**re: Grading Plan Review
Proposed High-Rise Development
1209 St. Laurent Boulevard – Ottawa, Ontario**

to: 1209 St. Laurent Limited Partnership – **Mr. Jordan Allen** - jallen@canderel.com
cc: Fotenn – **Mr. Paul Black** - black@fotenn.com
date: May 3, 2023
file: PG5216-MEMO.01

- Site Grading, Drainage, and Sediment & Erosion Control Plan – Project No. CCO-22-1215 – Drawing No. C101 – Revision 3 dated April 20, 2023.

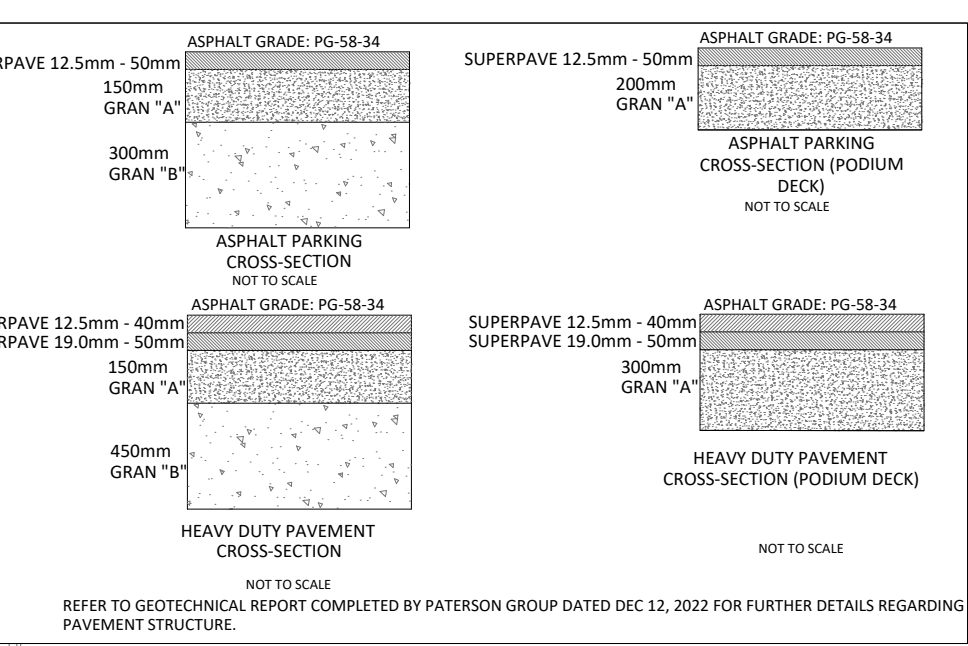
Based on our review of the above-noted drawing and the subsurface conditions present at the subject site, the proposed grading is considered acceptable from a geotechnical perspective. A silty clay deposit was not encountered during the geotechnical investigation and therefore permissible grade raise restrictions are not applicable to the subject site. Tree planting setbacks, based on the City of Ottawa 'Tree Planting in Sensitive Marine Clay Soils - 2017 Guideline', are not required. Further, the proposed high-rise development will be founded upon a bedrock bearing surface.
